From: Paton, Julie <Julie.Paton@lancashire.gov.uk>
Sent: 15 September 2023 14:41
To: Planning
Subject: RE: 3/2023/0649 Barn adj Tile Croft Chipping Road Longridge PR3 2NB
Attachments: 3 2023 0649 Overlay.pdf

Reference 3/2023/0649
Location Barn adj Tile Croft Chipping Road Longridge PR3 2NB
Proposal We've got an application to convert an agricultural building into two dwellings

DRAWING TITLE  
Existing & Proposed Site Plans

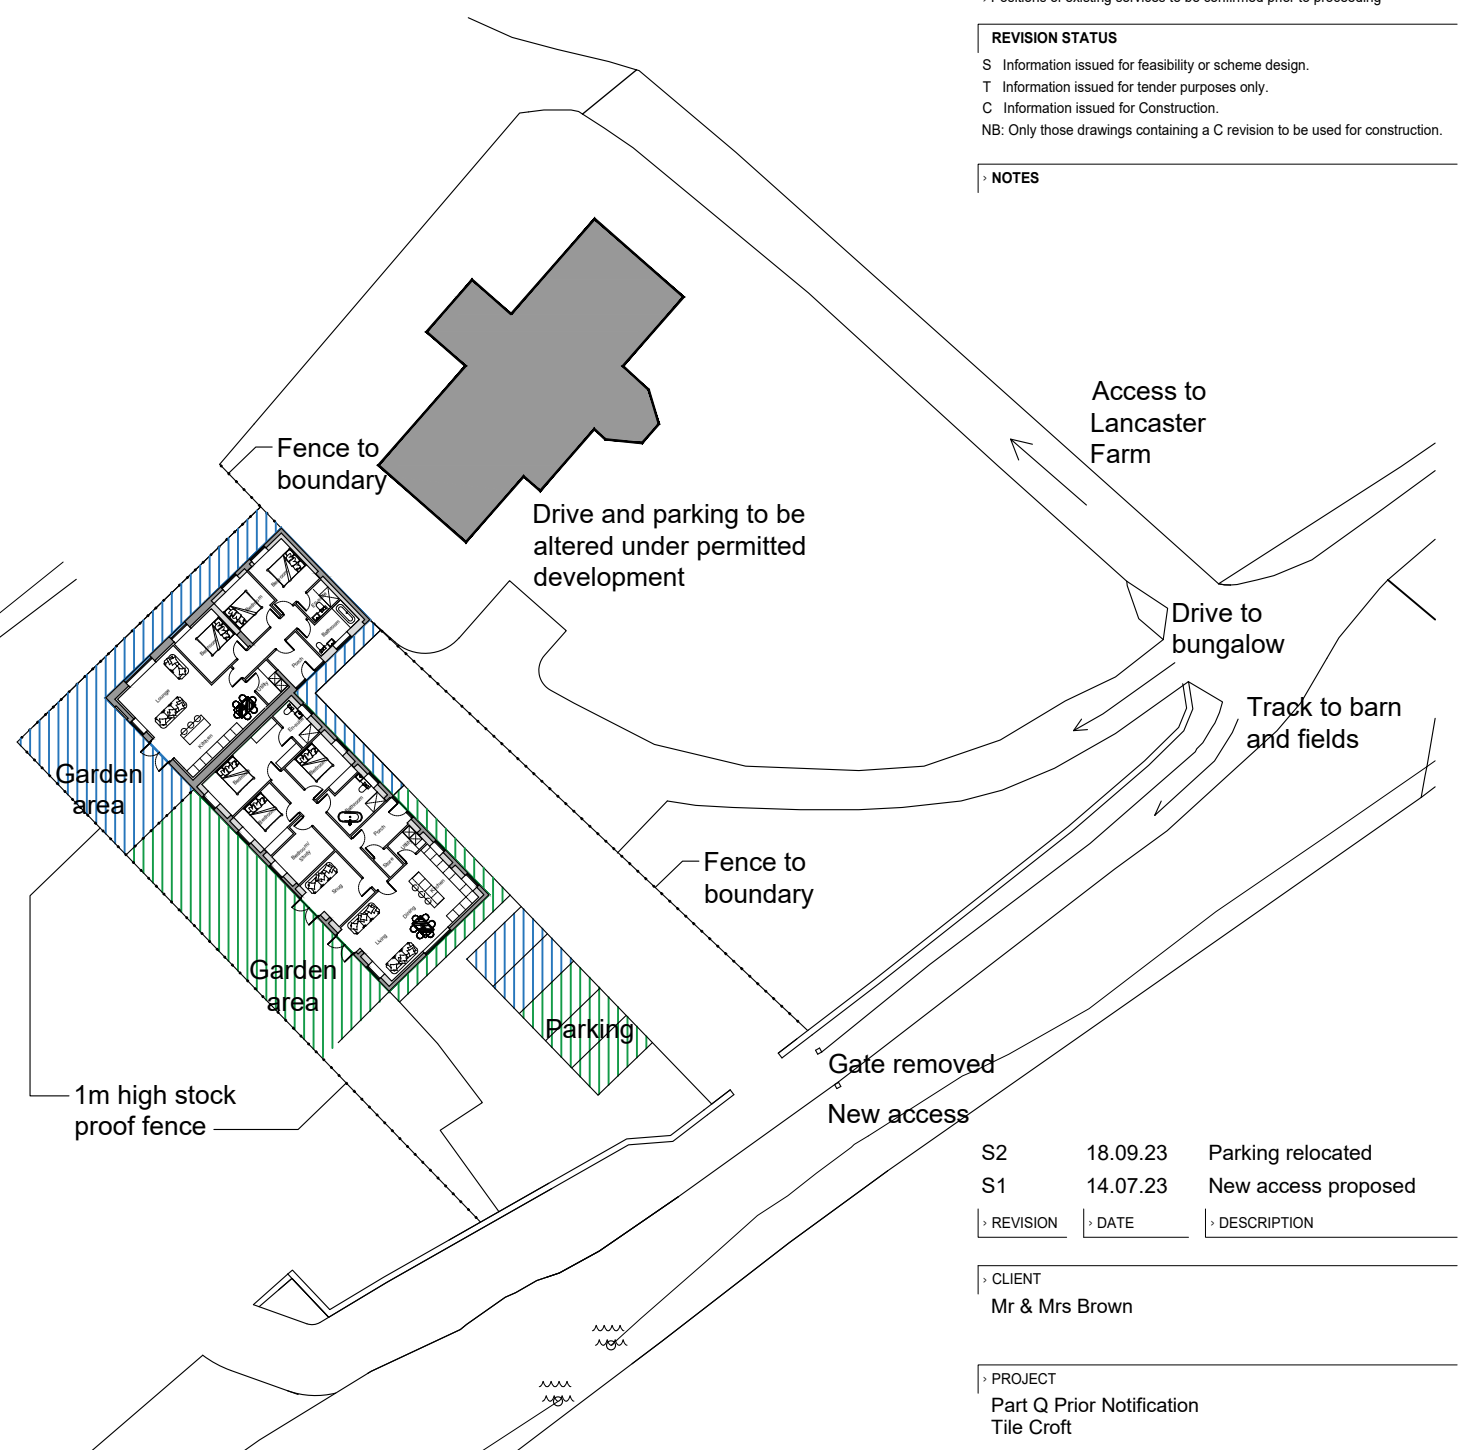
The proposed parking area will obstruct footpath FP0341068, as shown on the attached overlay, triggering a Diversion Order under the provisions of the Town and Country Planning Act 1990 Section 257 (TCPA90 S257). TCPA90 S257 orders are administered by the authority that is considering, or has granted the planning permission, in this instance Ribble Valley Borough Council.

DRAWING TITLE
Existing & Proposed Site Plans

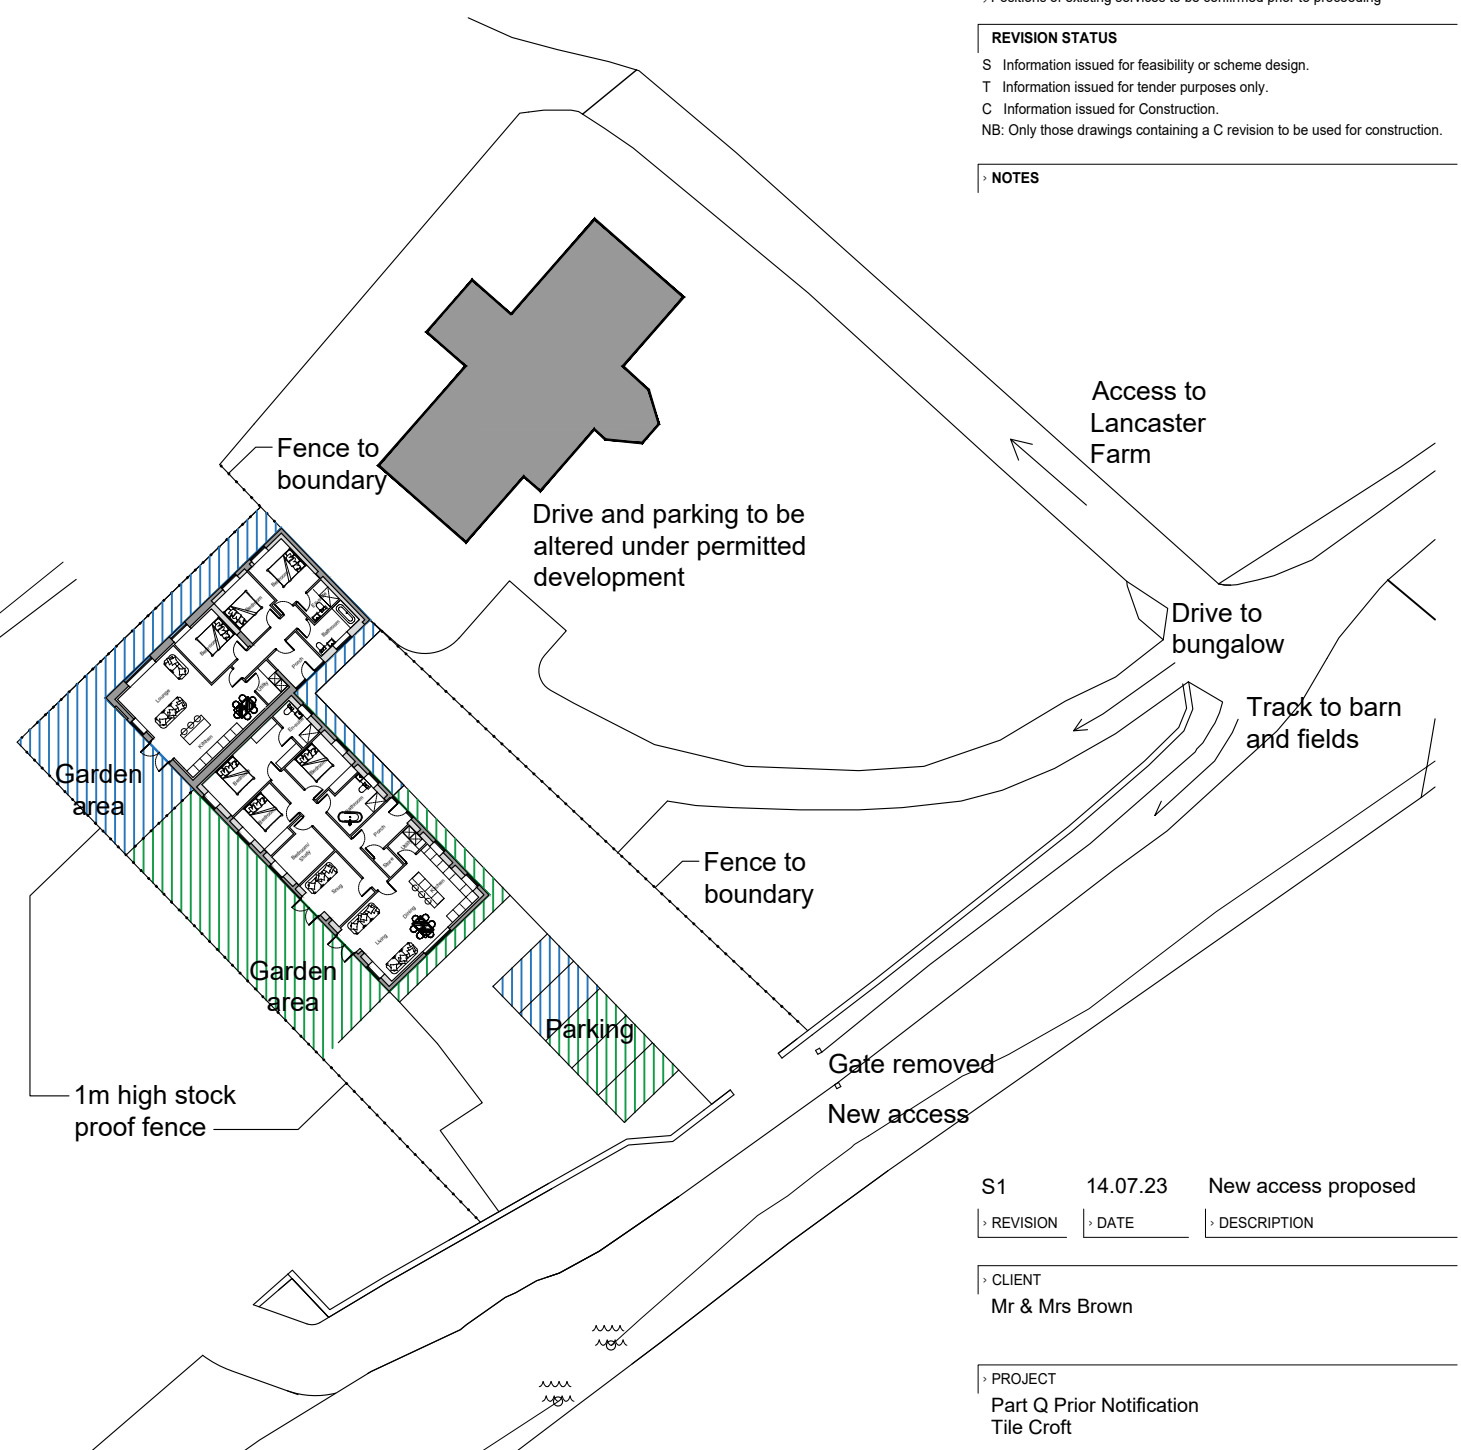
The detail of the exact alignment of the new route, the construction specification and any association works would need to be agreed with public rights of way before the necessary TCPA90 S257 Order is made. I can advise that the new route must have a minimum width of 2 metres, have a firm properly constructed surface with no gates or stiles crossing the new route.
